## PLANNING CONSULTATION RESPONSE

| Application No             | 2025/0610                                                                                                     |
| Proposal                   | Outline development of five residential dwellings and associated infrastructure considering access and scale. |
| Consultee                  | Highways DC                                                                                                   |

Title
SITE ACCESS & PROPOSED LEVELS

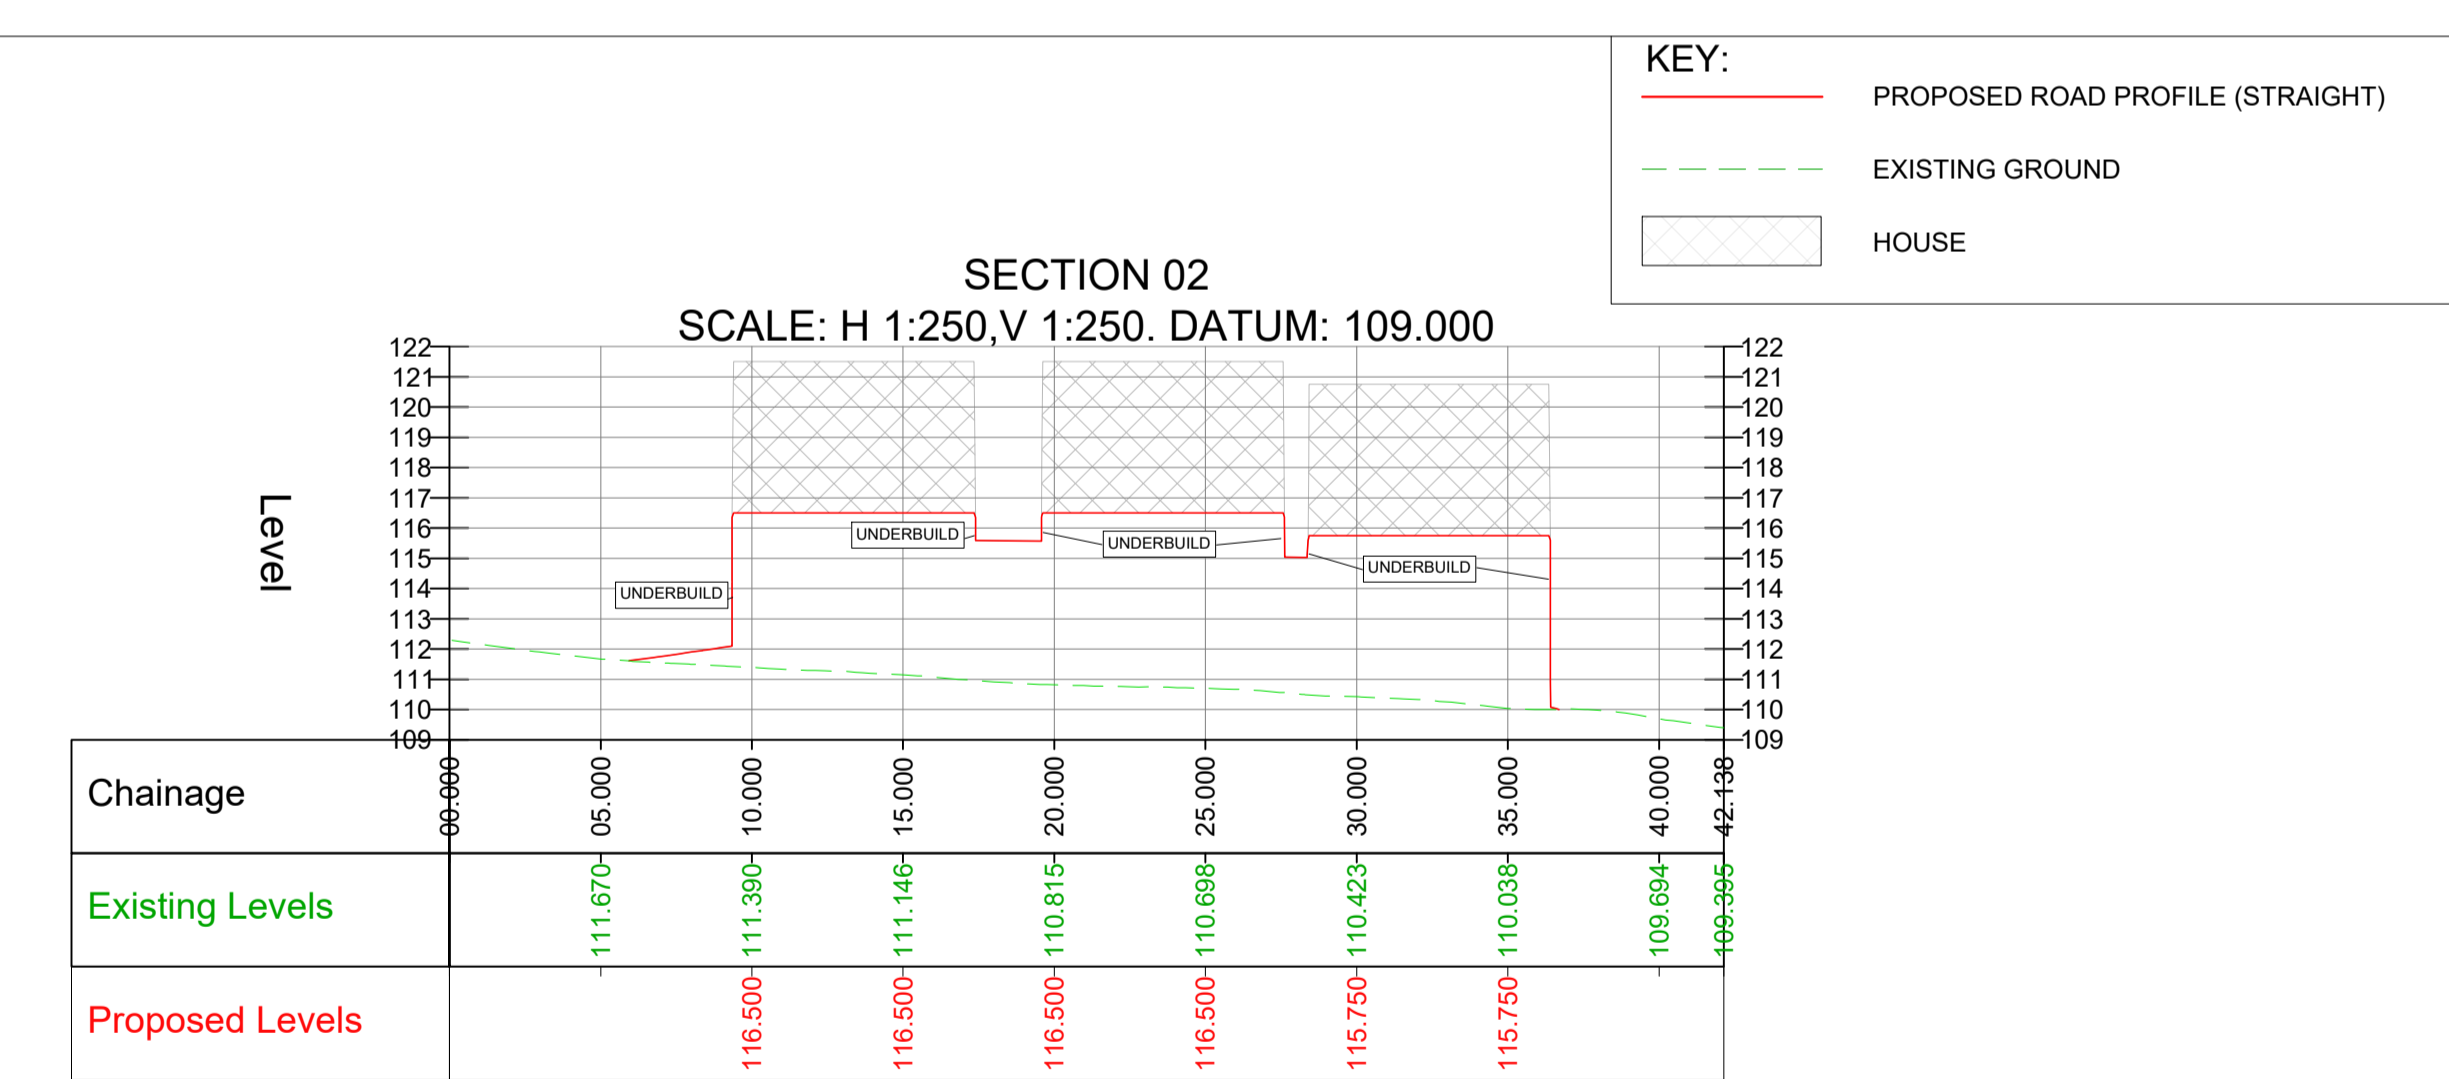
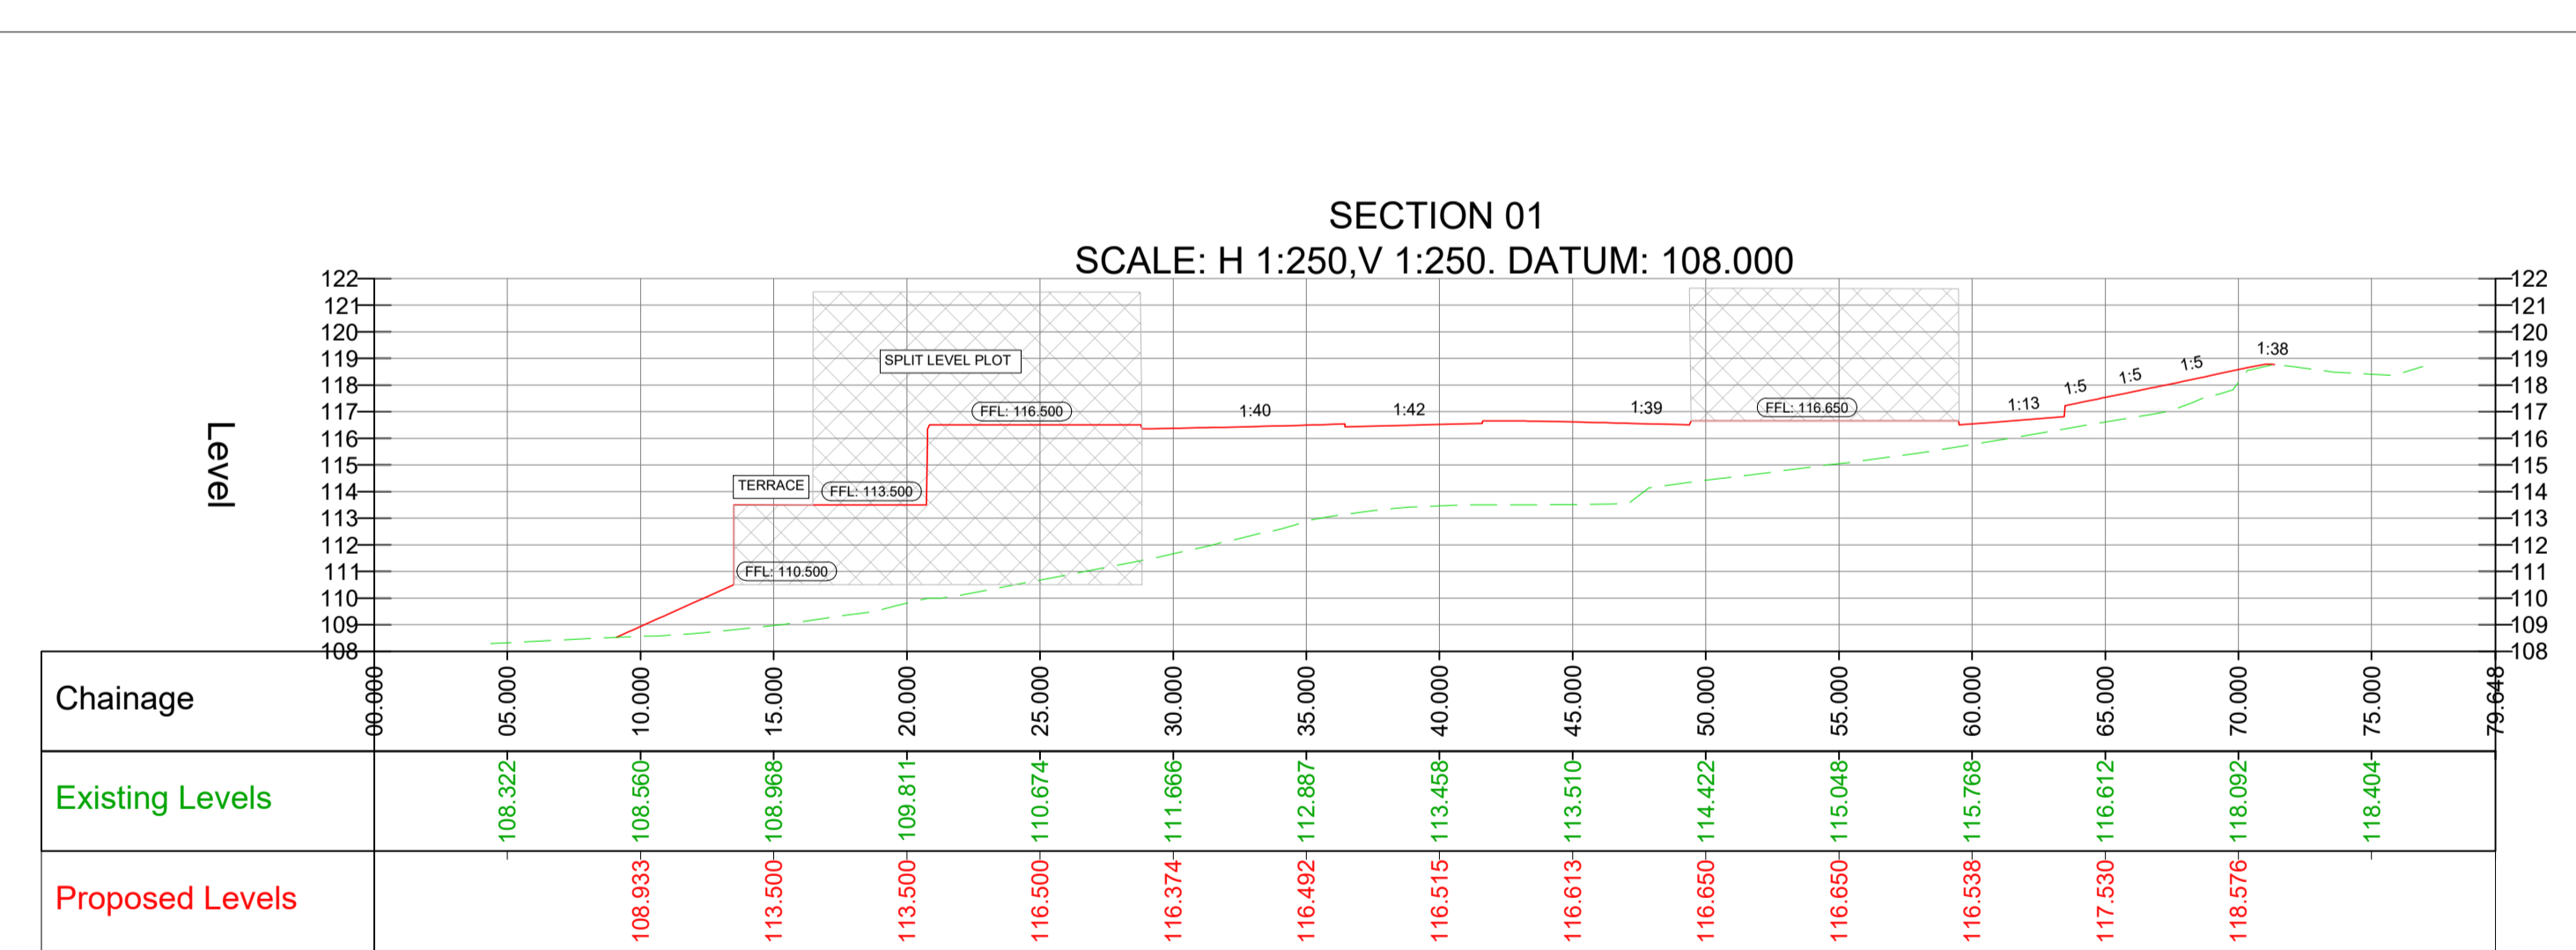
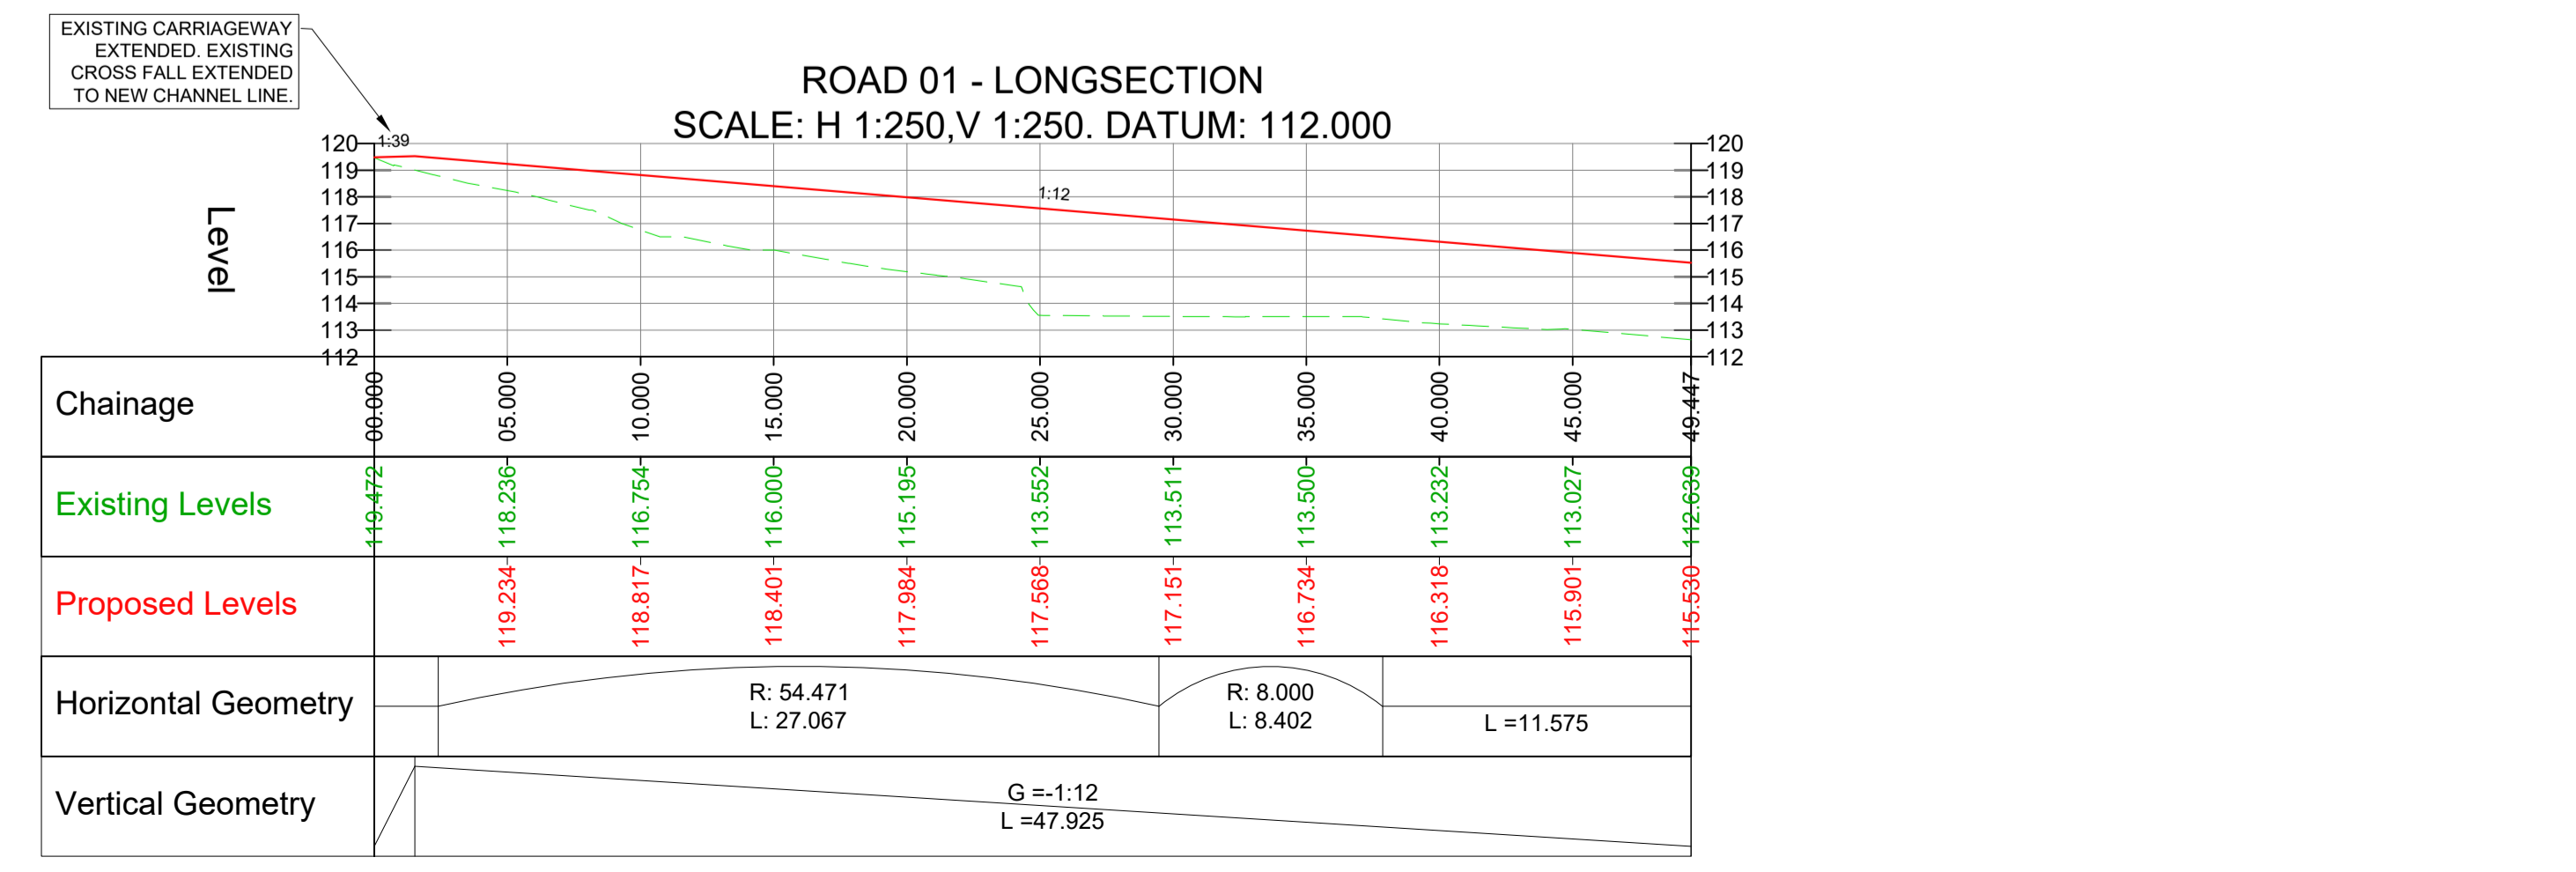
- All parking spaces within the site now have a clear 6m of manoeuvring space.
- No designated visitor parking is to be provided, it is intended for any visiting vehicles to park on the carriageway of the private drive which is of sufficient width to allow two vehicles to pass.

- A swept path manoeuvre has been provided which demonstrates that a large car is able to turn within the head of the private drive. Although the manoeuvre involves back-and-forth shunting manoeuvres (a 5-point turn), given that the alternative means of exiting the site would require a driver to reverse around a bend up a 1:12 gradient, it is considered likely that drivers would elect to turn within the site.
